STATE OF NORTH CAROLINA
DEPARTMENT OF TRANSPORTATION

SUBJECT: Request for Modification of the Phased Section 404 Individual Permit and Section 401 Individual Water Quality Certification, Neuse River Riparian Buffer Authorization for the construction of the Triangle Expressway Southeast Extension from NC-55 Bypass in Apex to I-40, Wake and Johnston Counties. TIP Nos.: R-2721, R-2828, and R-2829. Federal Aid Project No. 0540047.

We are requesting a modification to Section 404 Authorization (SAW-2019-02240) and the associated 401 Individual Water Quality Certification (Permit No. 20181249). This request is prompted by the Design-Build Team identifying an opportunity to reduce the overall length of the Neuse River Bridge by approximately 290 feet while maintaining the FEMA and NC Floodplain Mapping “no-rise” condition at Sites 14 and 15. This has numerous benefits that are described in further detail below. It is estimated that the construction cost savings to the project by reducing the length of the Neuse River Bridge is on the order of \$2 million.

SITE 14

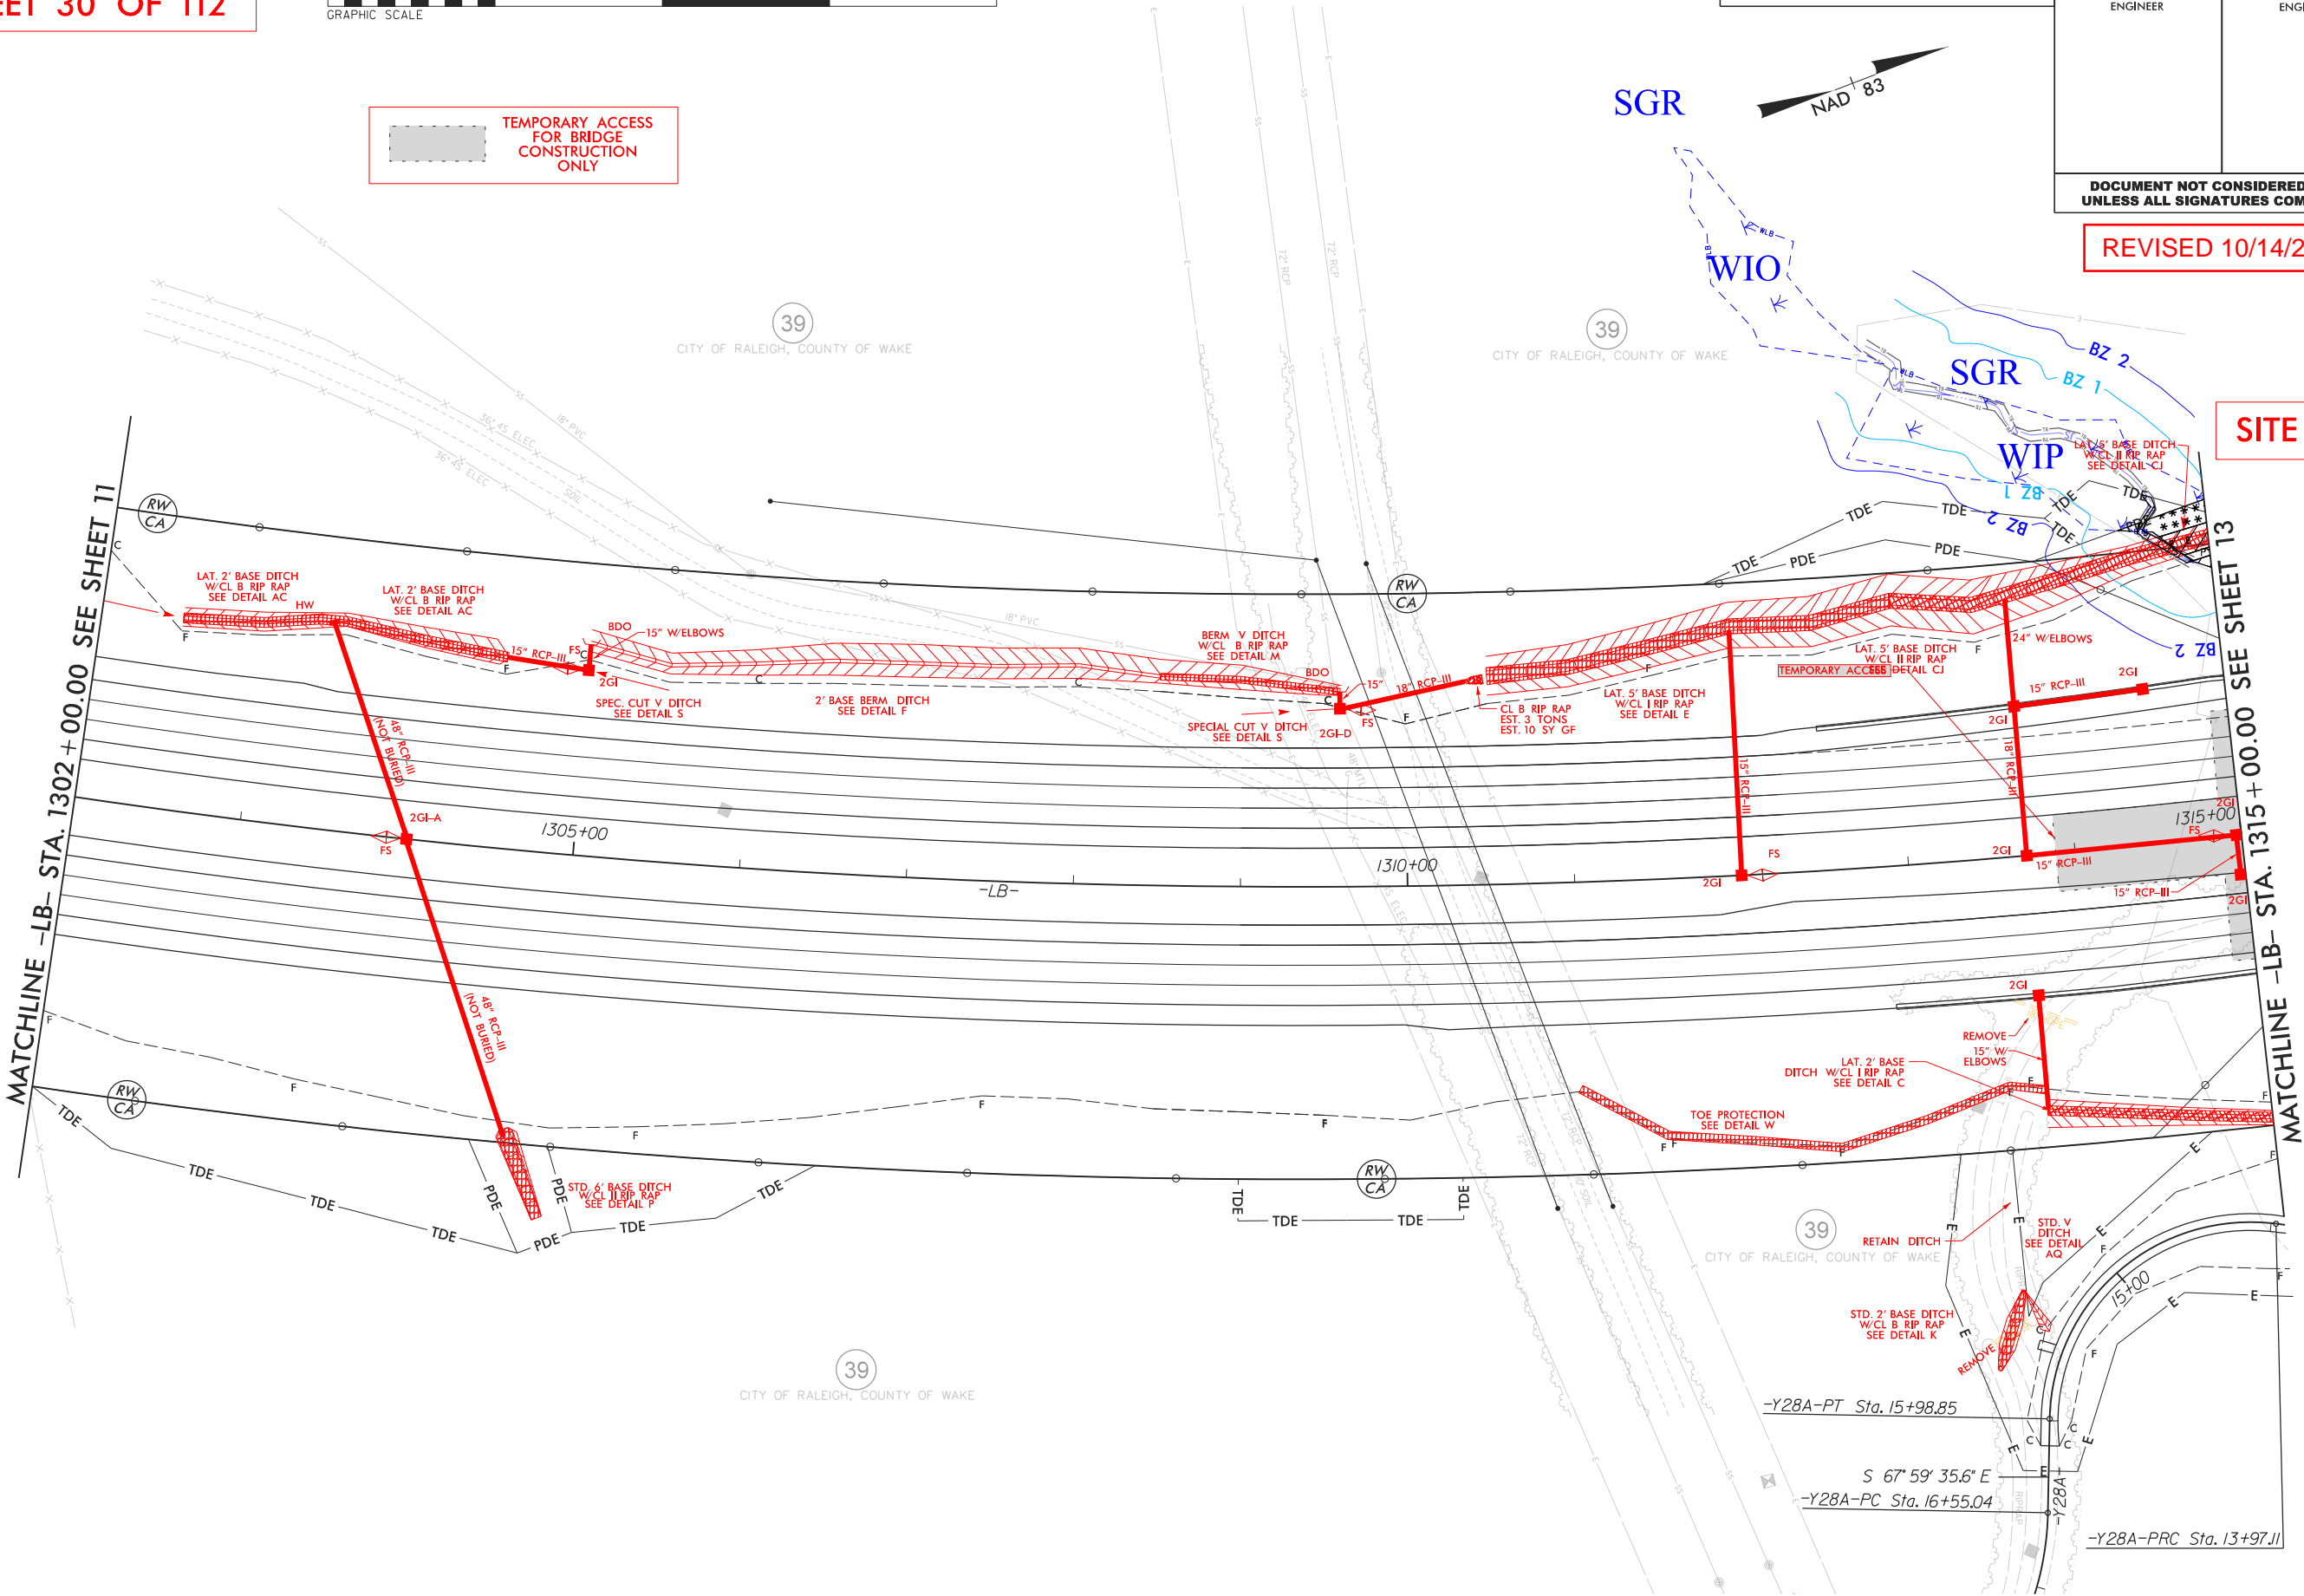
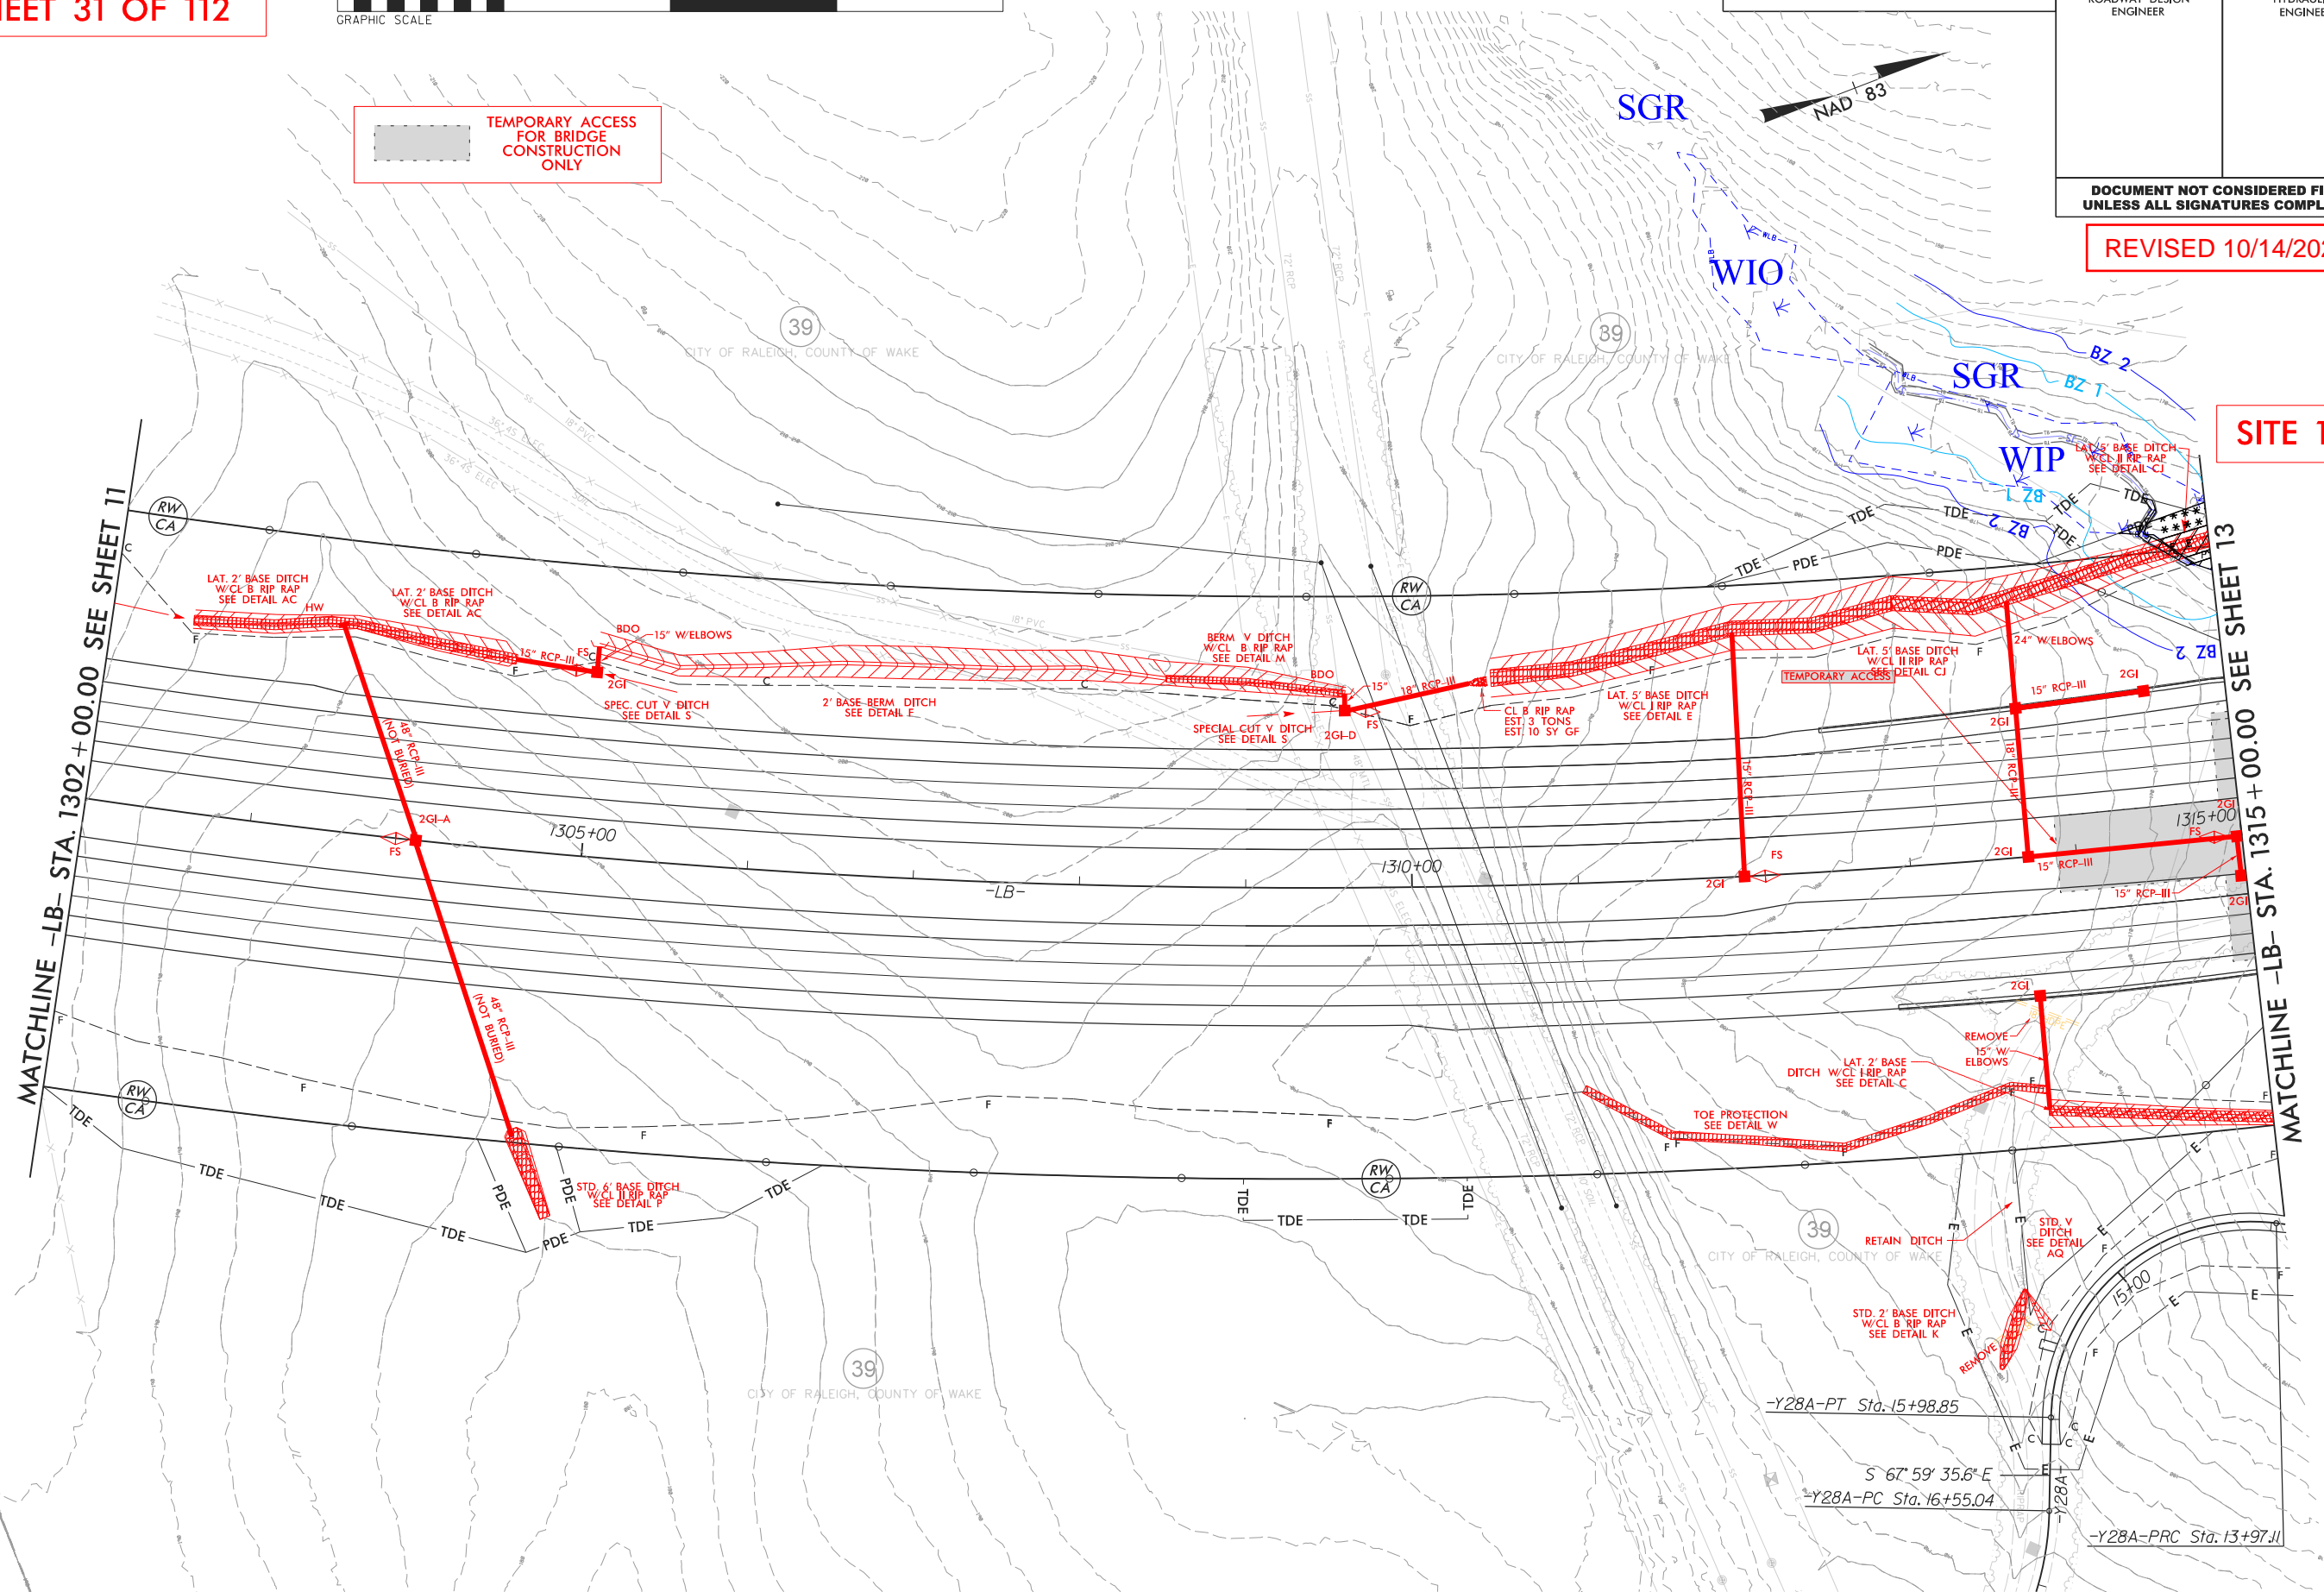
Site 14: WIP and SGR

- Fill in Wetland: 0.036 ac (previously 0 – increase of 0.036 ac)
- Excavation in Wetland: 0.021 ac (previously 0.002 – increase of 0.019 ac)
- Mechanized Clearing in Wetland: 0.030 ac (previously 0.011 – increase of 0.019 ac)
- Permanent Surface Water Impacts: 500 lf (previously 442 – increase of 58 lf)
- Buffer Zone 1 Impacts: 27,754 sq ft (previously 24,910 sq ft – increase of 2,844 sq ft)
 - Wetlands in Zone 1 (WIP): 1,611 sq ft (previously 40 sq ft – increase of 1,571 sq ft)
- Buffer Zone 2 Impacts: 18,077 sq ft (previously 16,255 sq ft – increase of 1,822 sq ft)
 - Wetlands in Zone 2 (WIP): 1,280 sq ft (previously 156 sq ft – increase of 1,124 sq ft)

Permit Site 14 has increased impacts due to the lateral base ditch going around the end of the permanent bridge fill. These impacts were reduced to the greatest extent possible. Steeper slopes are not possible given the topography of the area. A retaining wall option was explored, but it did not reduce impacts to the jurisdictional resources in this area because regardless of steepening the bridge abutment fill slope and bringing the lateral base ditch closer to the NC 540 alignment, the flow in stream SGR would still have to be intercepted and conveyed through the lateral base ditch to the Neuse River, resulting in similar impacts. During the early planning phases of the project, the design team thoroughly explored potential realignment options, including the bank excavation approach outlined in Alternative 6 as a possible mitigation measure. After careful review, it was determined that excavation would likely create additional impacts to the City of Raleigh's sewer line, which already presents challenges due to a critical crossing and the limited space around existing manholes.
